The Secretary  
NSW Planning, Industry & Environment

27 October 2021

I refer to the Department's below email of 18 October 2021 regarding the Environmental Impact Statement (EIS) for State Significant Development SSD-17647189 Access Logistics Park for 'Demolition and bulk earthworks, 13-lot Torrens Title subdivision, construction of internal roads, infrastructure and utilities, construction and operation of Warehouse 1 with associated offices, car parks, hardstands, and landscaping' located at 884-928 Mamre Road, Kemps Creek (Lots 52 & 53 DP 259135) in the Penrith City Local Government Area (LGA). Submissions need to be made to the Department by 15 November 2021.

LOT 2 - Site Plan / Ground Floor Plan / Fencing Plan

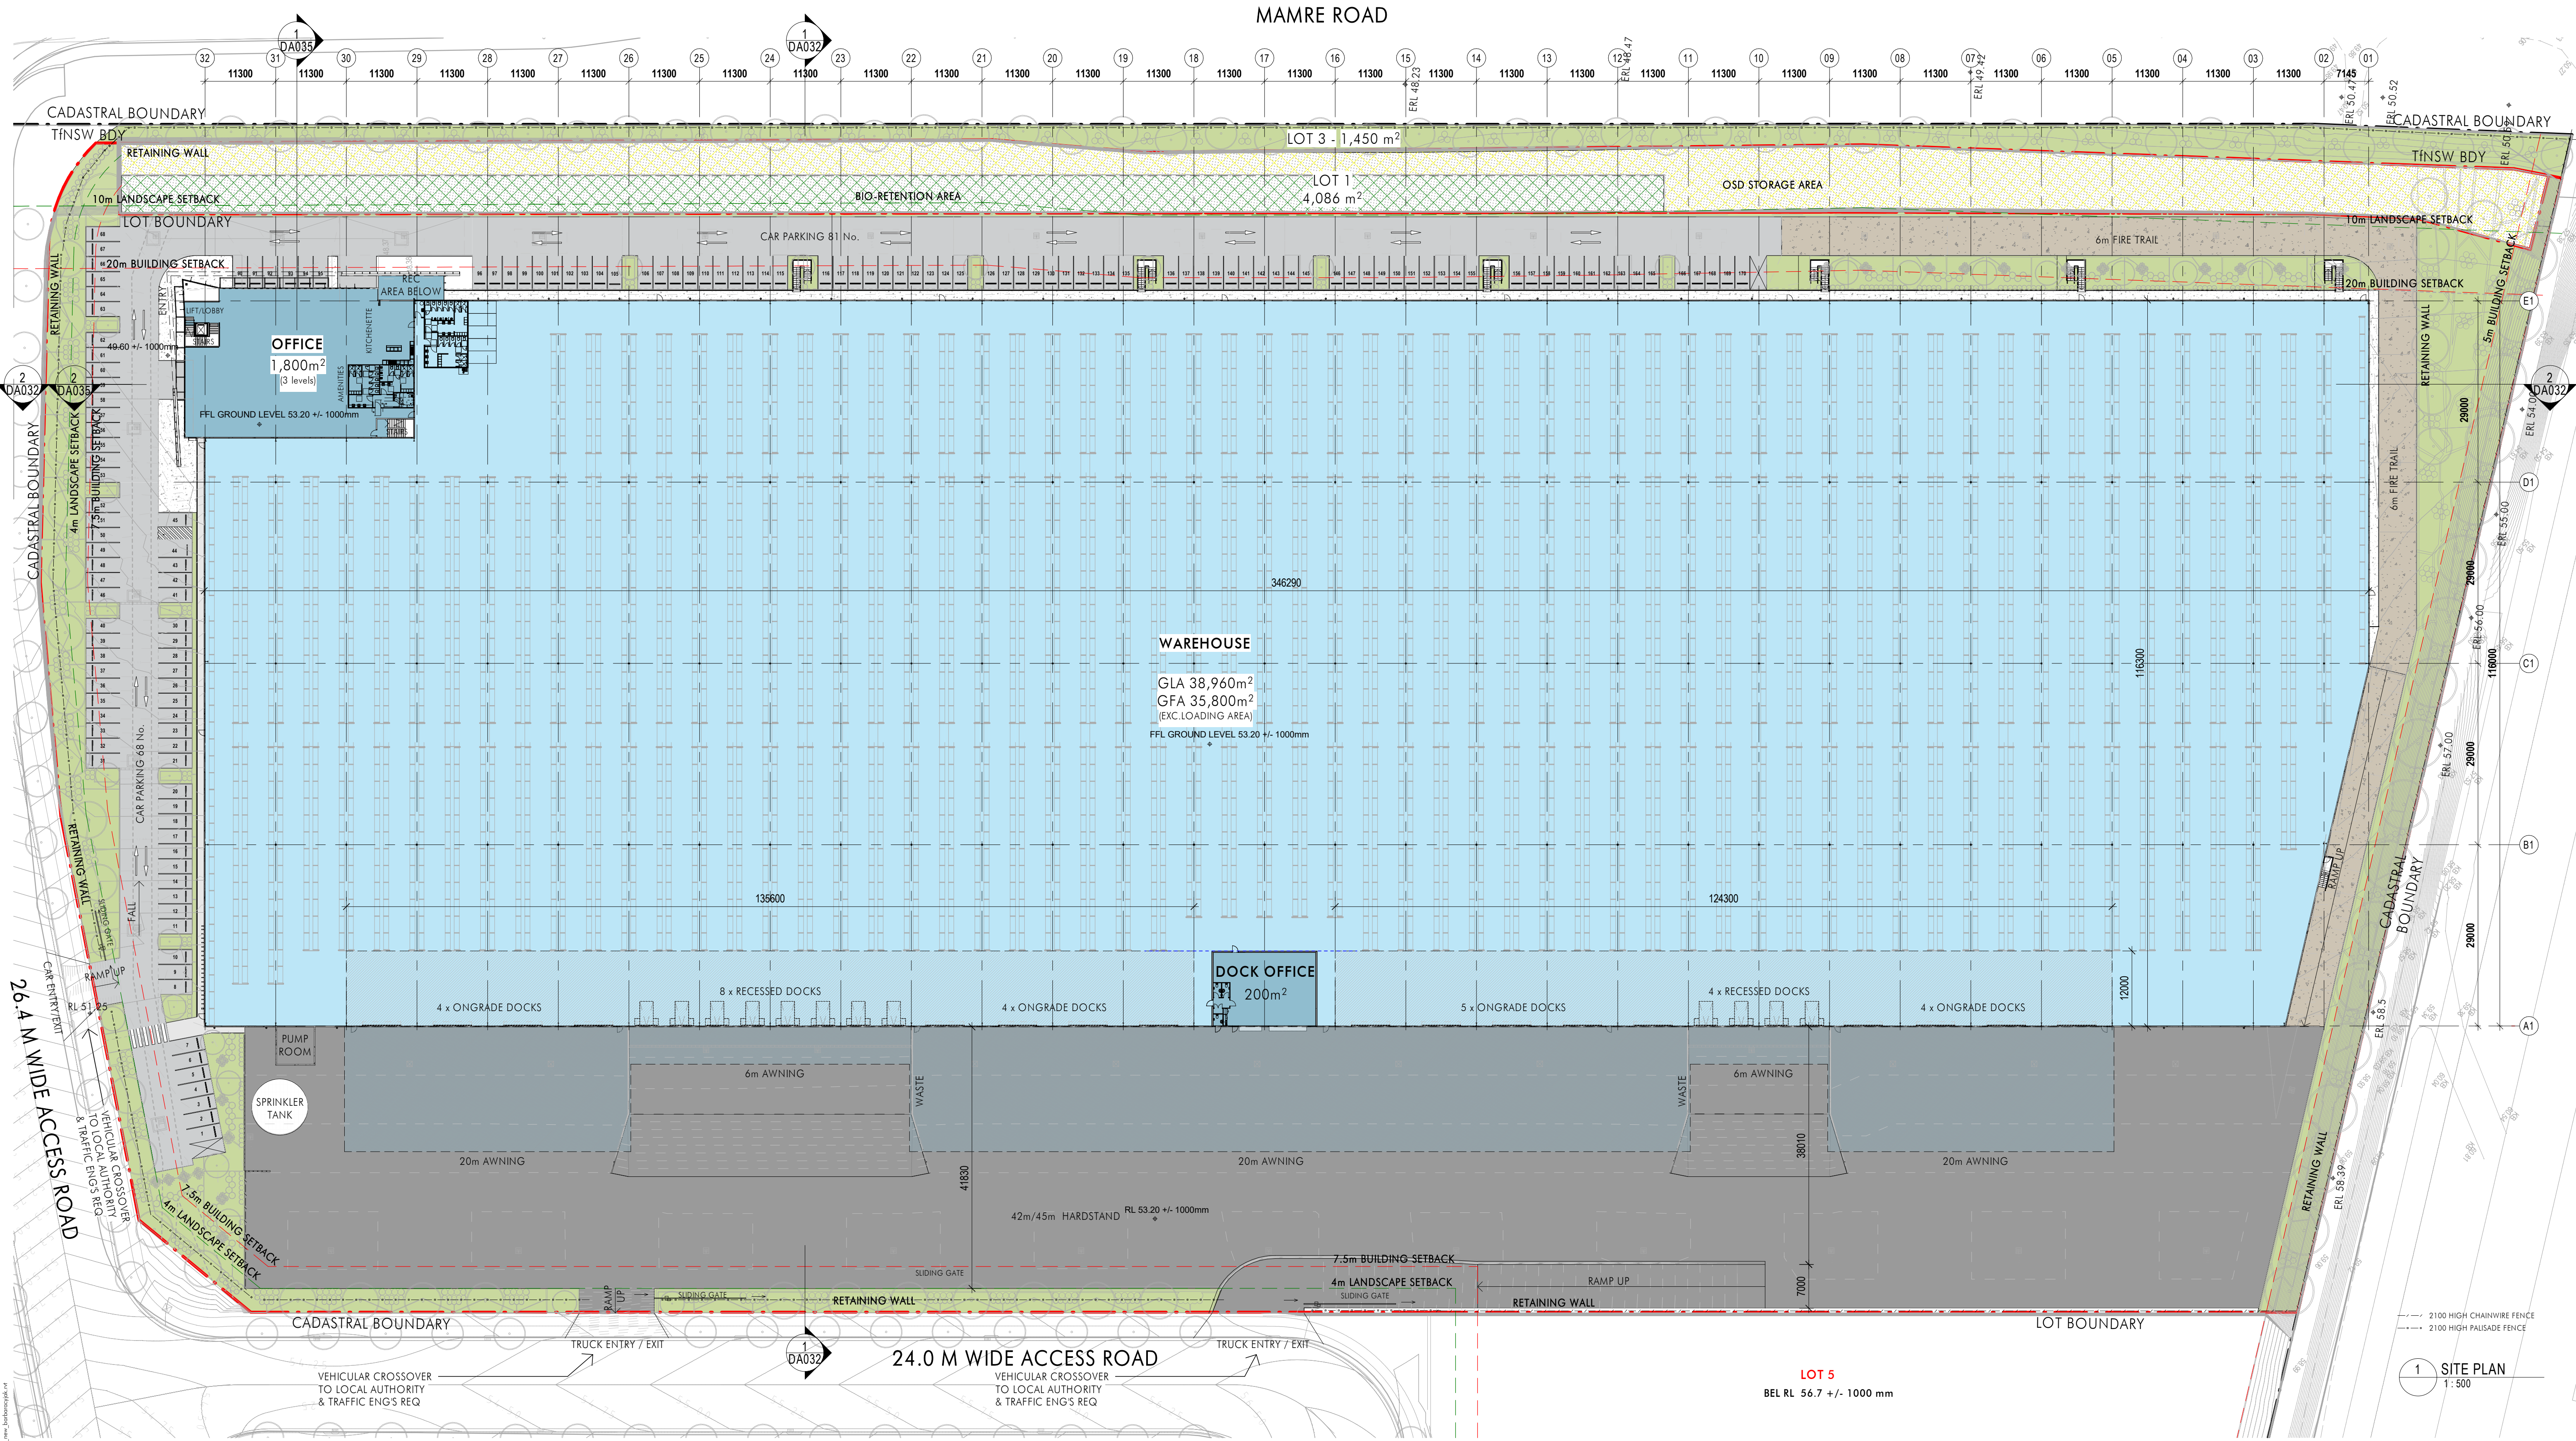
From the Architectural Plans it does not appear any provision has been made for a padmount substation likely to be required for Warehouse 1.

As previously advised, Endeavour Energy is urging applicants /customers to engage with an Electrical Consultant / Accredited Service Provider prior to finalising plans to in order to assess and incorporate any required electricity infrastructure. In so doing the consideration can also be given to its impact on the other aspects of the proposed development. This can assist in avoiding the making of amendments to the plan or possibly the need to later seek modification of an approved development application.
